Ribble Valley Borough Council
Council Offices
Church Walk,
Clitheroe
Lancashire
BB7 2RA

Phone: 0300 123 6780
Email: developeras@lancashire.gov.uk
Your ref: 3/2026/0094
Our ref: 3/2026/0094/HDC/KW
Date: 13 March 2026

Location: Barns at Winckley Hall Farm Whalley Road Hurst Green BB7 9PN
Proposal: Proposed conversion of 2no. curtilage listed barns (Main Barn/Barn 2) to create 2no. dwellings and the re-building of a smaller stone barn (Barn 3) for ancillary use (re-built for safety/practicality).
Grid Ref: 370898 438399

Highway Development Control

drawing number
PL 1

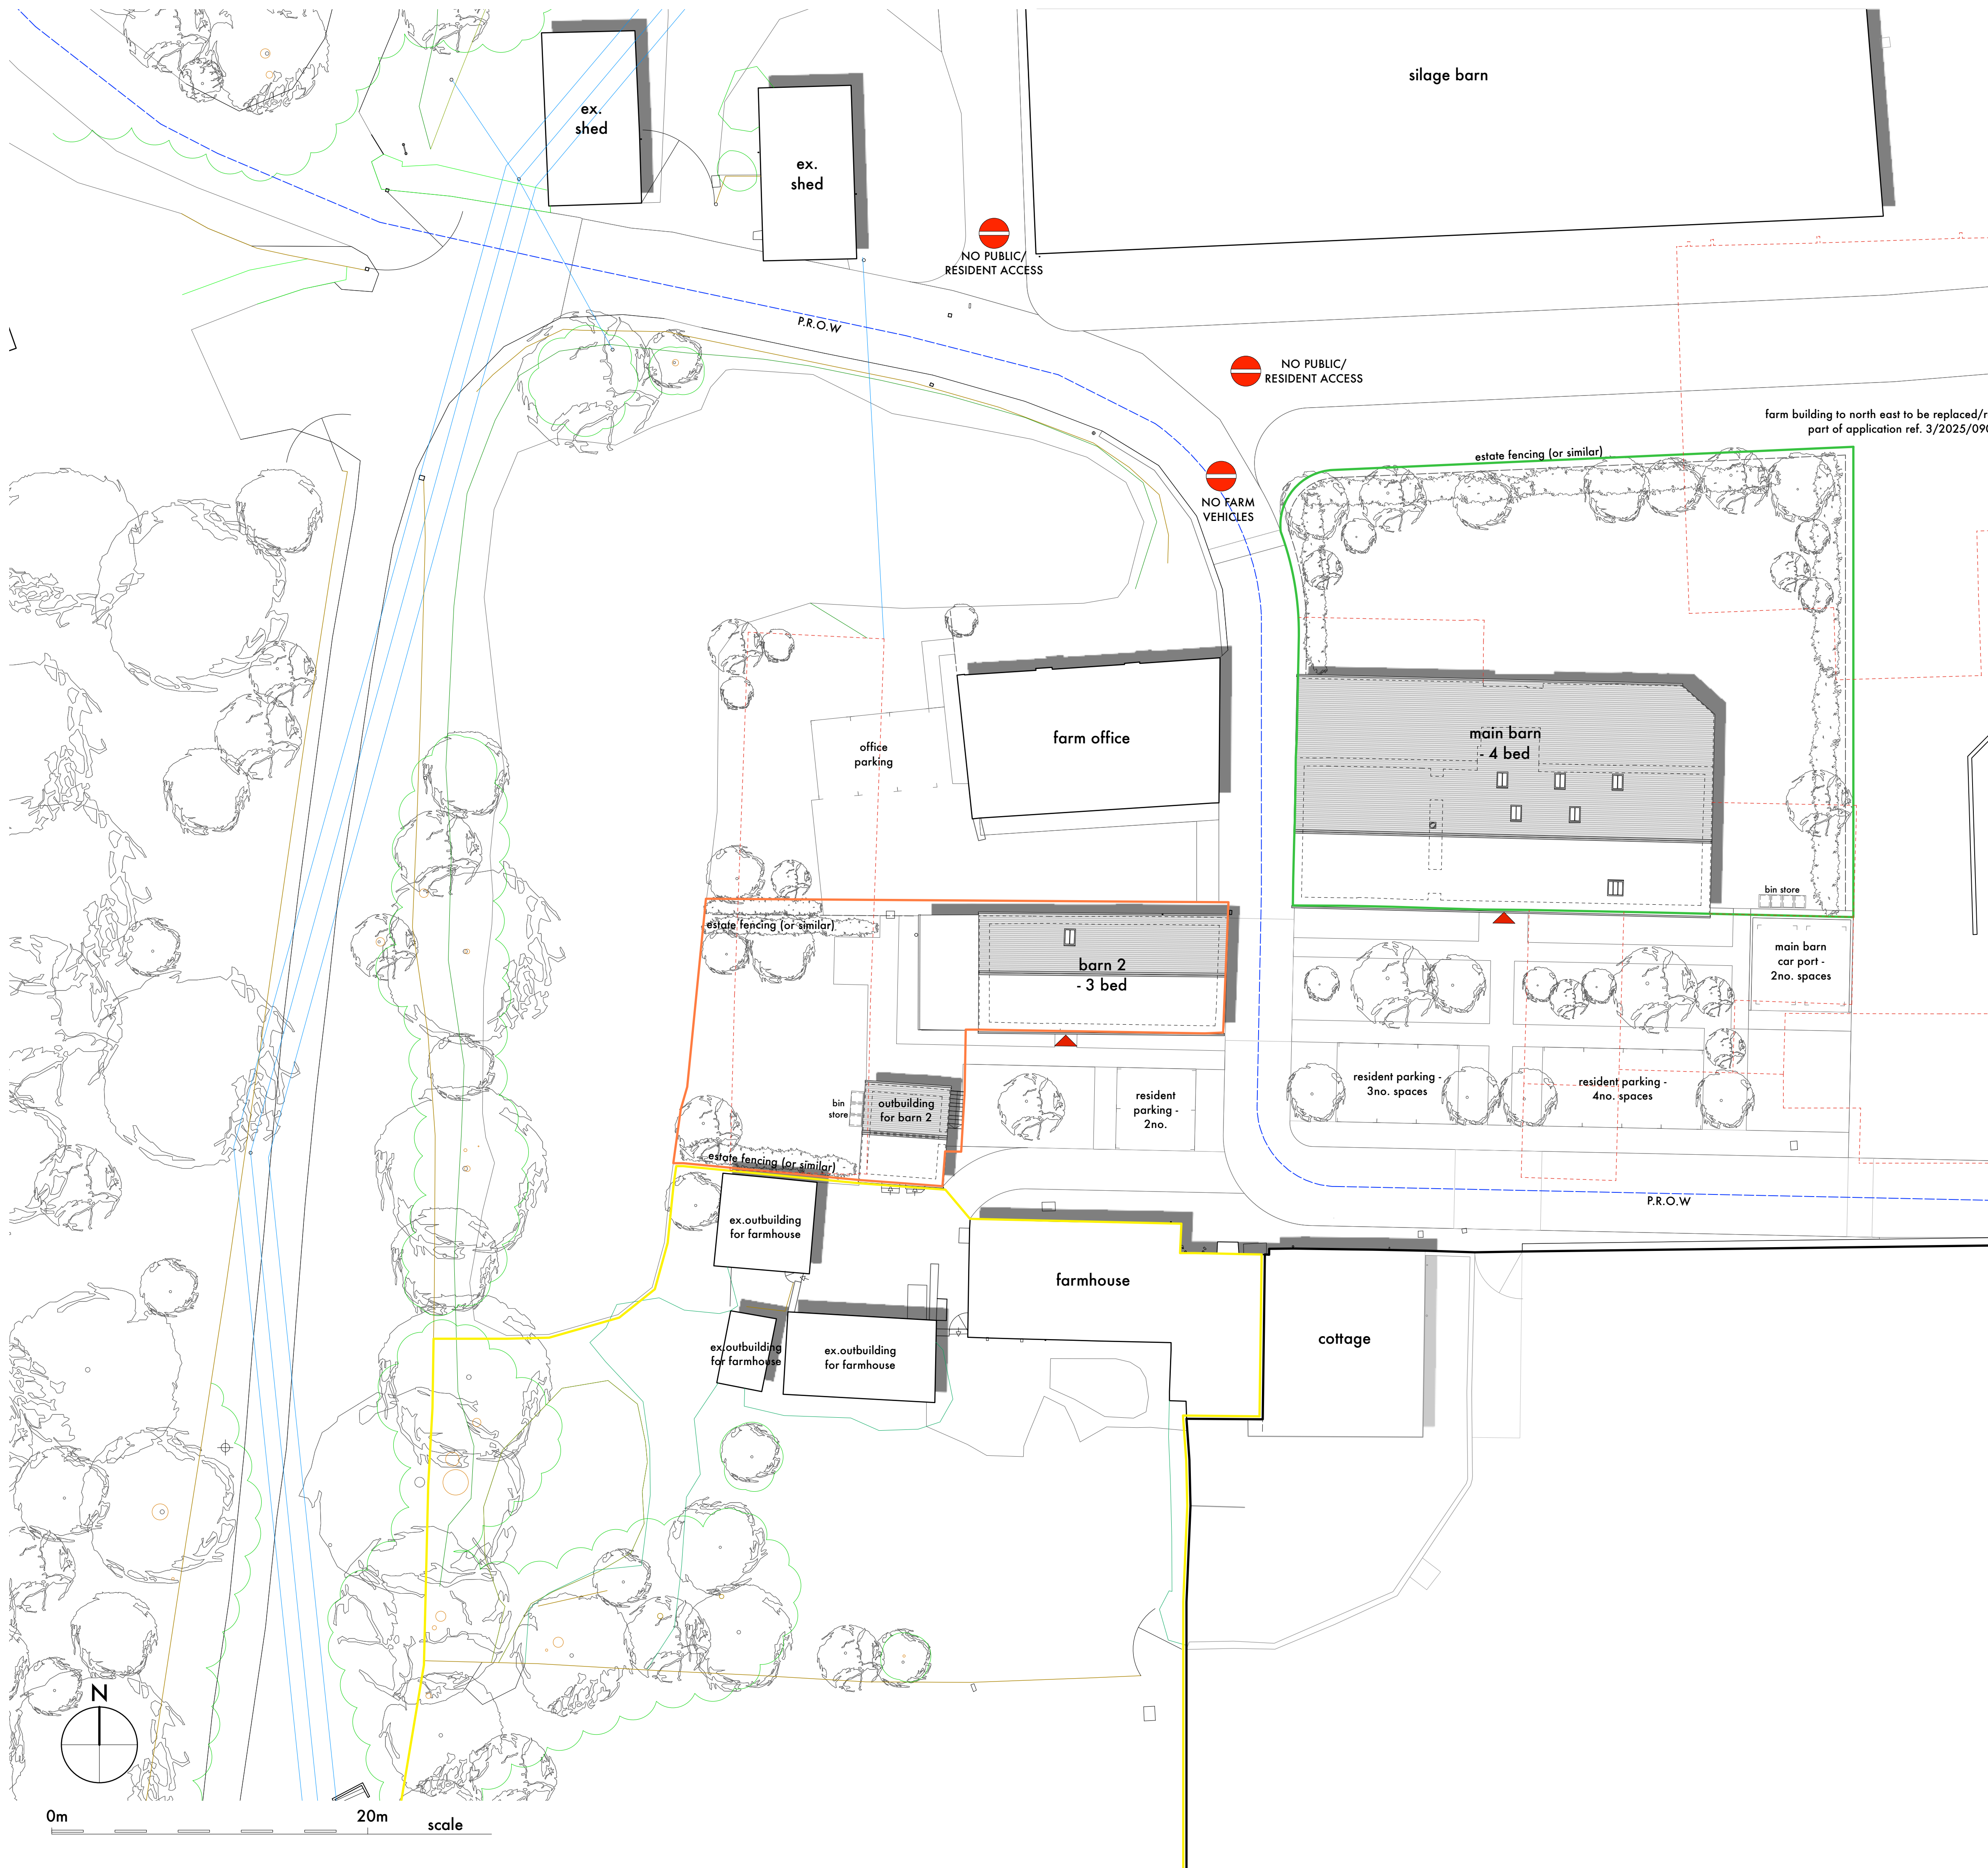
The LHA have reviewed drawing number PL 1 revision B titled Proposed Site Plan and are aware that site will create two dwellings and the re-building of a smaller stone barn (Barn 3) for ancillary use.

Barn 1, the main barn will be developed into a 4-bedroom dwelling, the main barn benefits from a carport on site that provides two off-street parking spaces. There is also seven car parking spaces to the south of the main barn that will also provide off street parking spaces. Barn 2 is proposed to be developed into a 3-bedroom dwelling and has 2 dedicated off-street parking spaces. It is understood that the cottage retains its own dedicated parking area outside the application boundary. As such, the LHA is of the opinion that the site has acceptable off-street parking provisions.

1. The development hereby permitted shall not be occupied or brought into use until the car parking and turning areas shown on the approved plan(s) have been provided in full and are available for use. The car parking and turning areas shall thereafter be kept available for the parking and manoeuvring of vehicles at all times.
